AN COIMISIÚN PLEANÁLA

ACP- 323969-25

Addendum C

Chronology

North Elevation - Retention Application
 1:100 @ A3

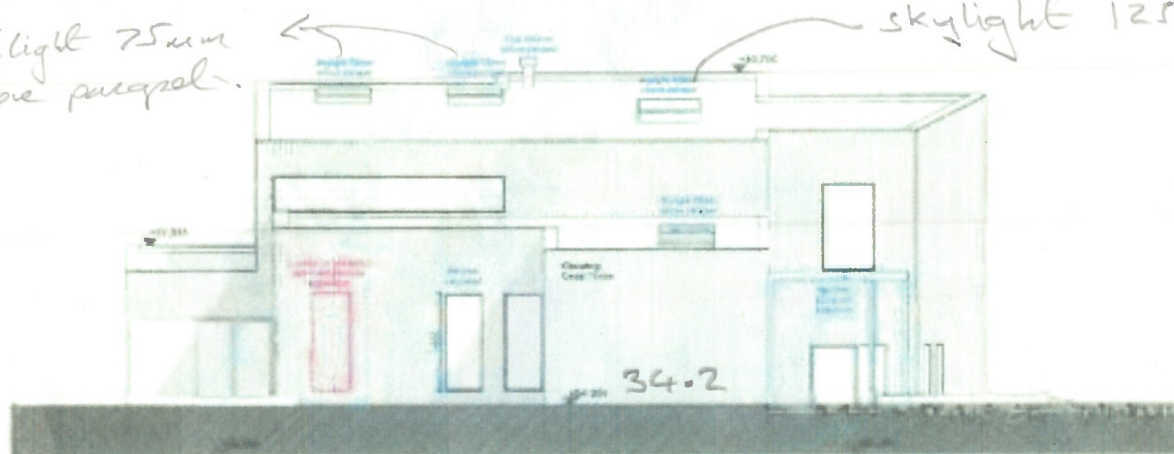
I object to the changes of rooflight dimensions and positions. The Planner's Report for the grant for permission for this development refers to drawing number 1719 -02. This is the architectural drawing with all requisite drawings for the planner's assessment. These drawings do not have any rooflights on the upper level. Therefore, no roof lights have been included in permission.

The upstands of the rooflights extend conspicuously above the parapet as does the flue which is installed (and not included in the grant for retention). The new architectural drawings 1719 R301 mis state the dimensions of these rooflights, the largest listed at 25mm above the parapet. These additions extend the ridge height significantly above the eaves of the neighbouring houses which contravenes permission and shows a complete disregard for the community. This was a very contentious issue explored at length in the previous associated planning application 18365 for this site.

PROJECT: House at Strandhill
DRAWING TITLE: First Floor Plan - Retention Application
STAGE: Retention Application
DATE: 25/09/2020

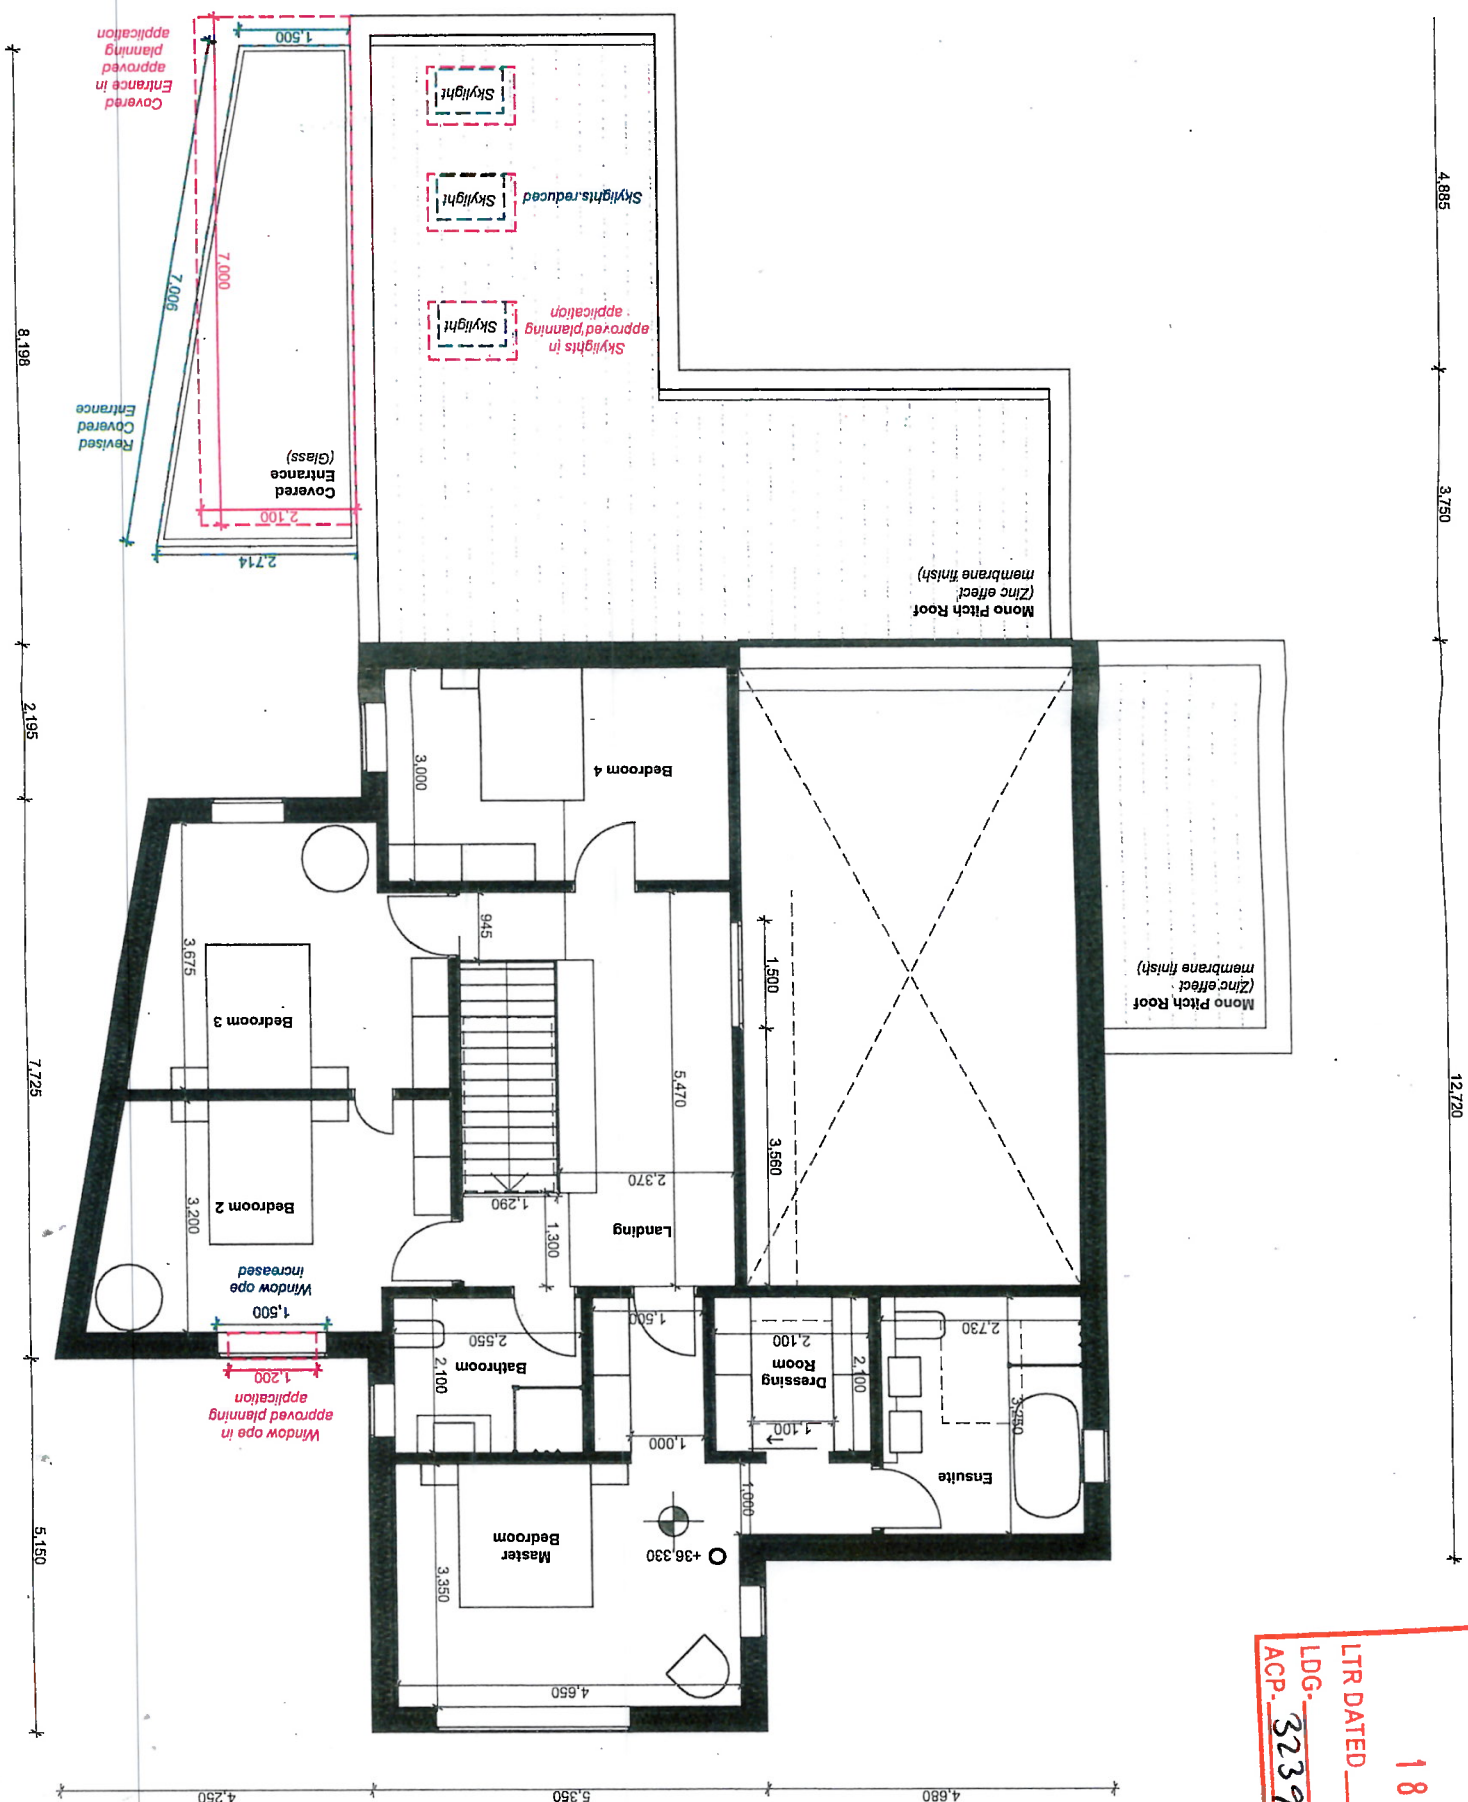
I object to window size alterations –

- The windows to the North in the first floor bedroom and the ground floor studio/office have been widened to allow in more light as facing north.
- The front door widened to allow a thick window next to it.
- The playroom window has moved position along the same south facing wall remaining the same size
- The basement window sill dropped to allow for a sliding door
- The living room window reduced in width as there was too much glass in this room, it is facing north.

PROJECT: House at Strandhill
DRAWING TITLE: Ground Floor Plan - Retention Application
STAGE: Retention Application
DATE: 25/09/2020

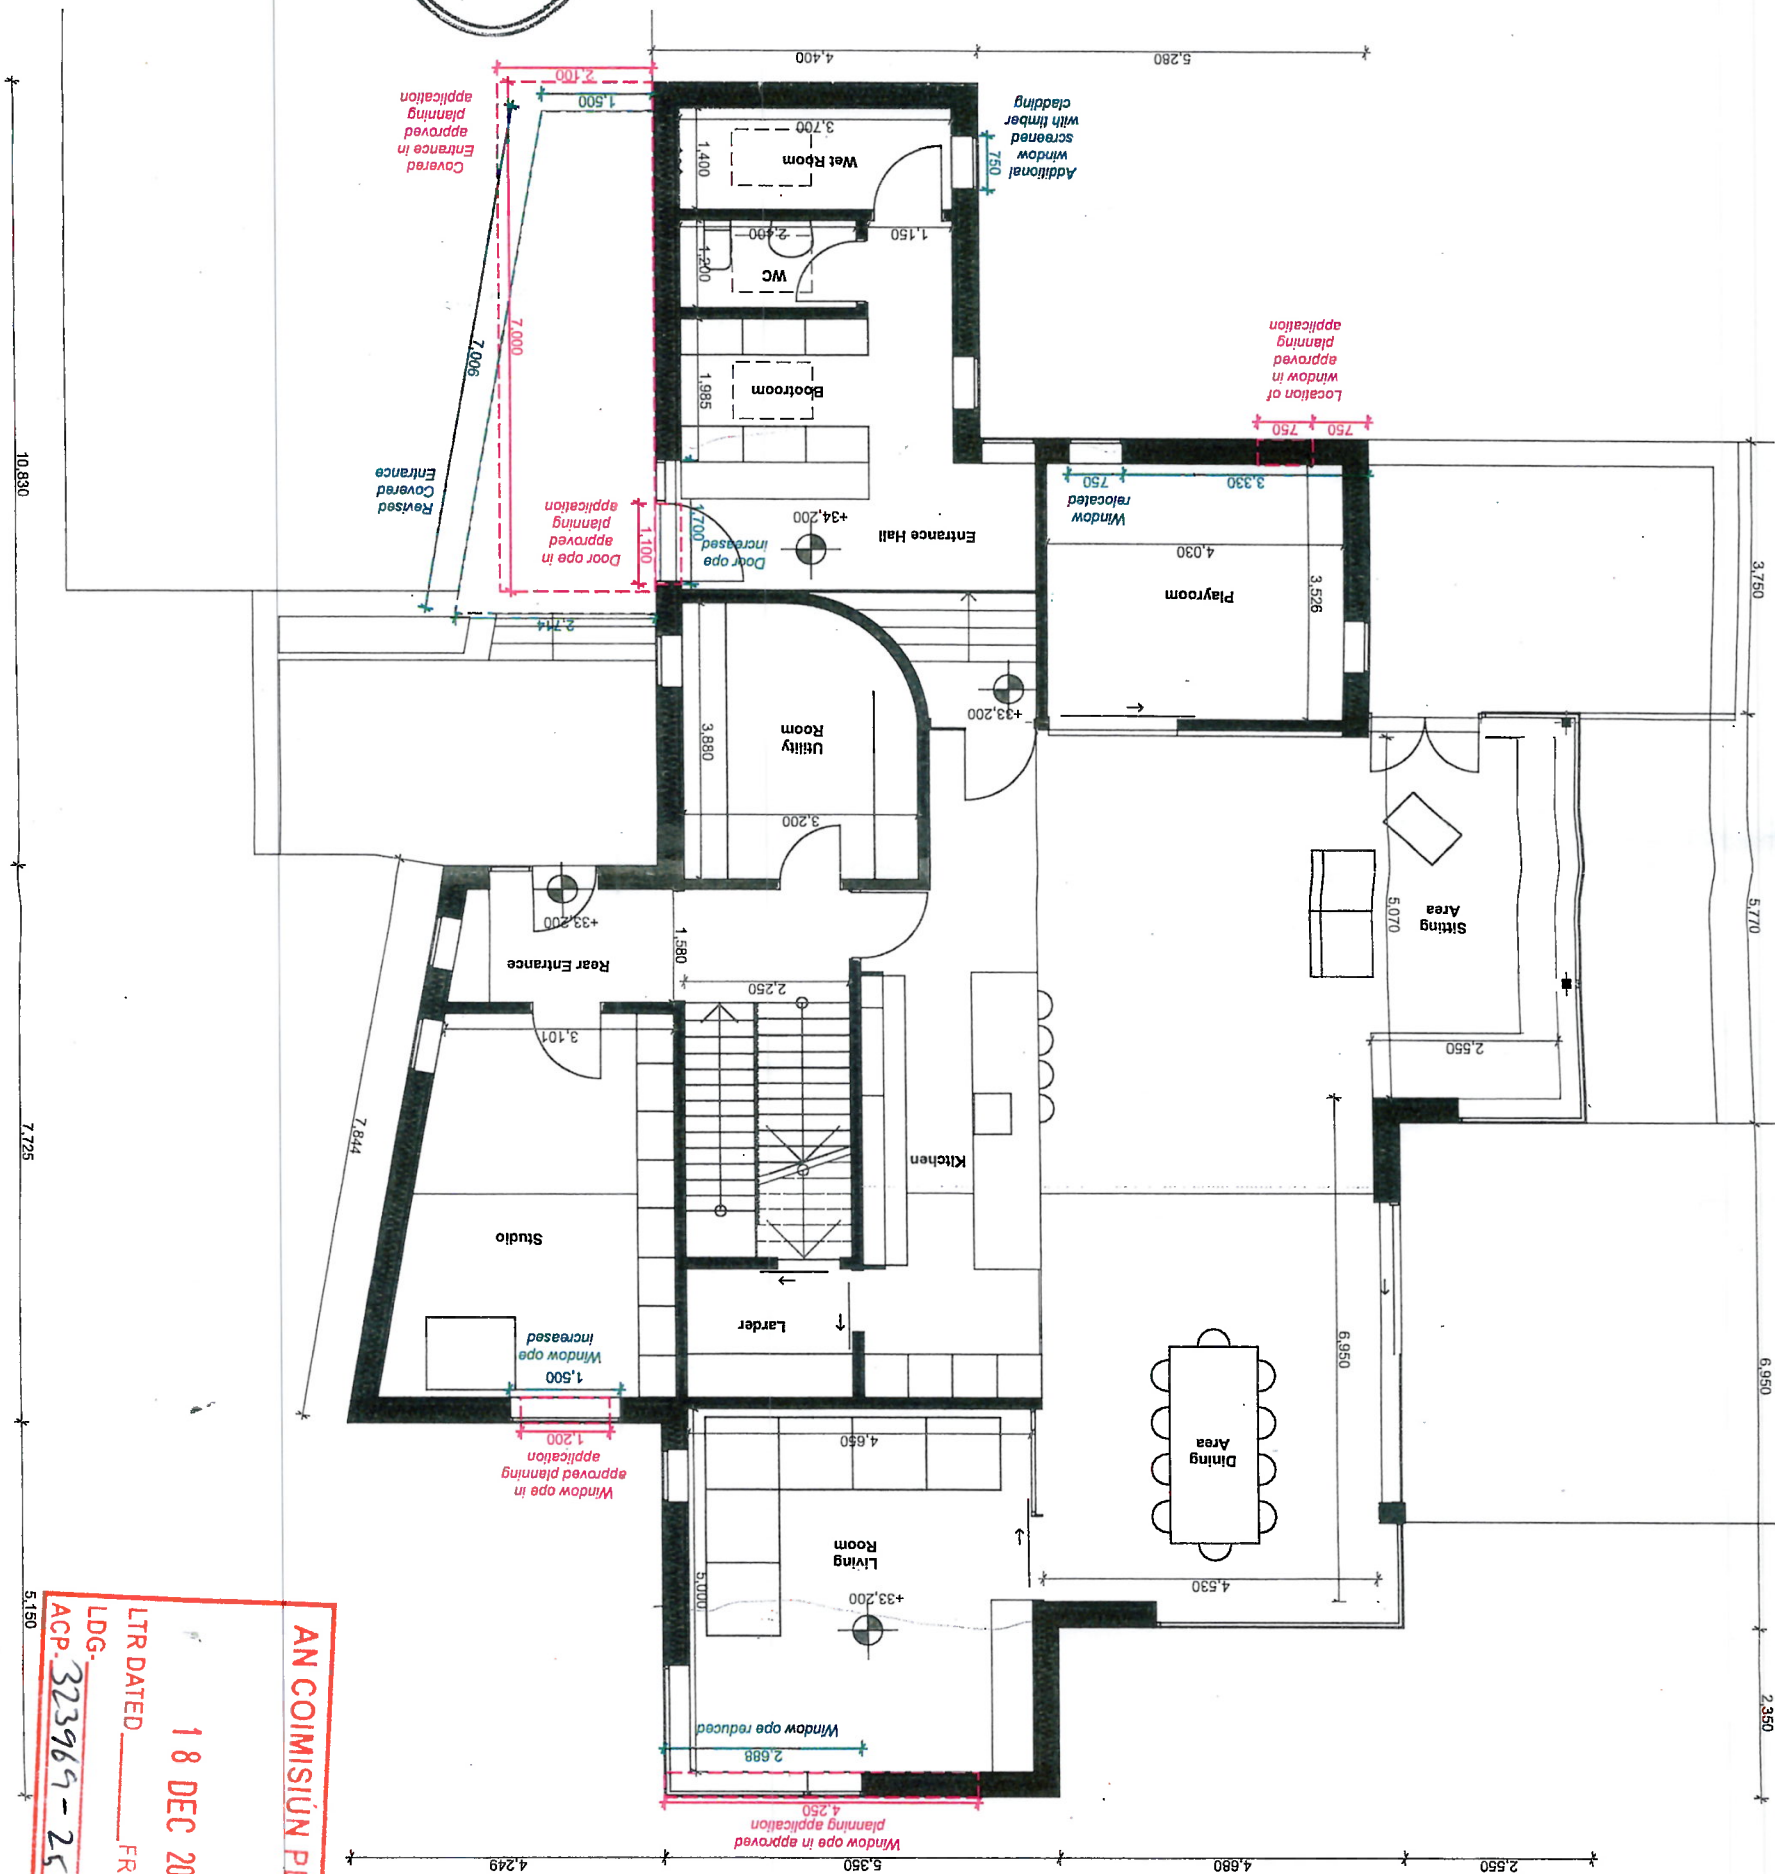
I object to the addition of a window on the Ground Floor –

PROJECT: House at Strandhill
DRAWING TITLE: Basement Plan - Planning Application
STAGE: Retention Application
DATE: 02/09/2020

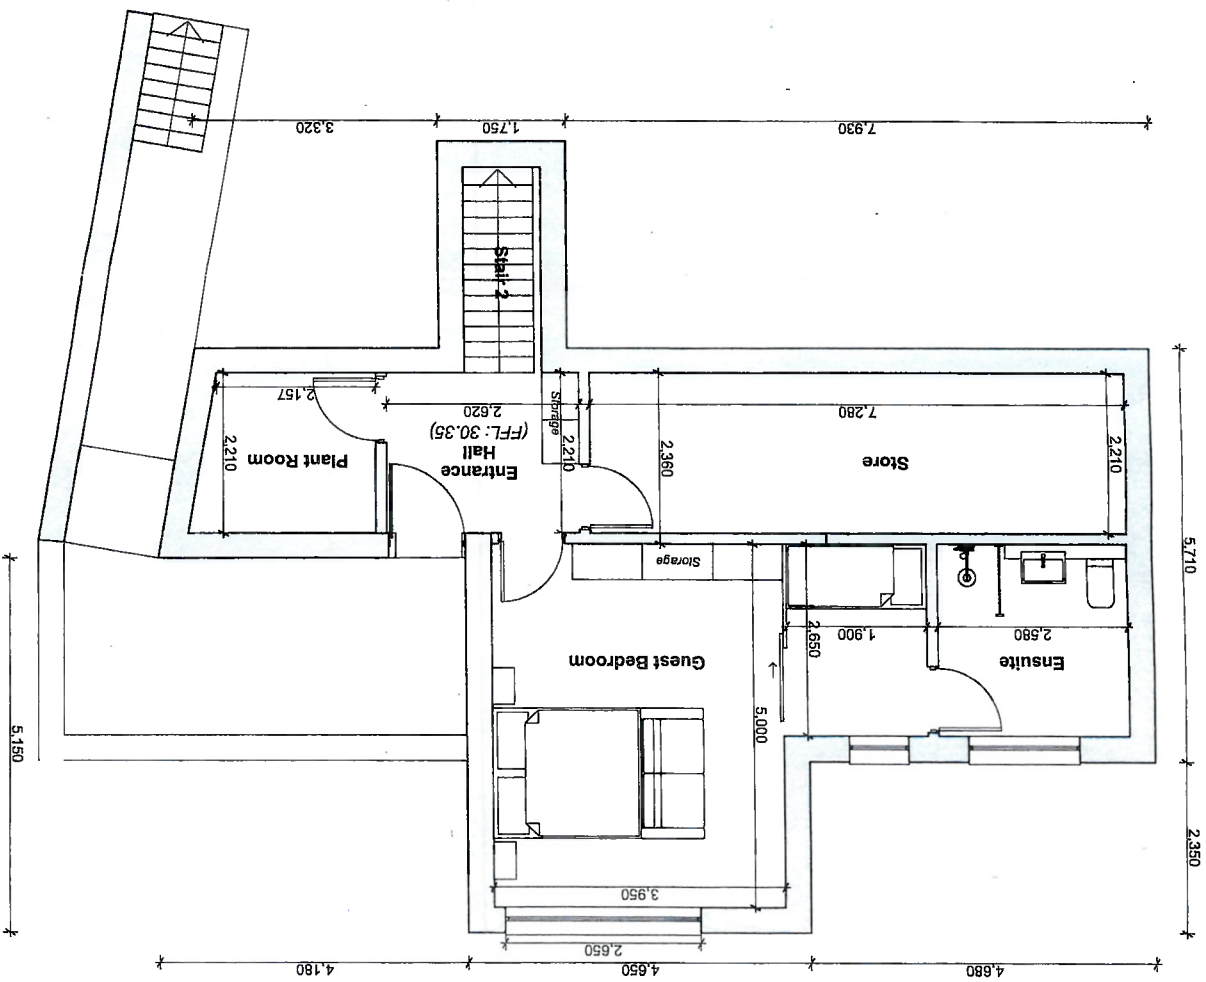
I object to the change of basement window to a sliding door. This indicates that the basement is *at* ground level not below which changes the overall height of the house to 10.5 meters exceeding the 9.5m limit granted in permission.
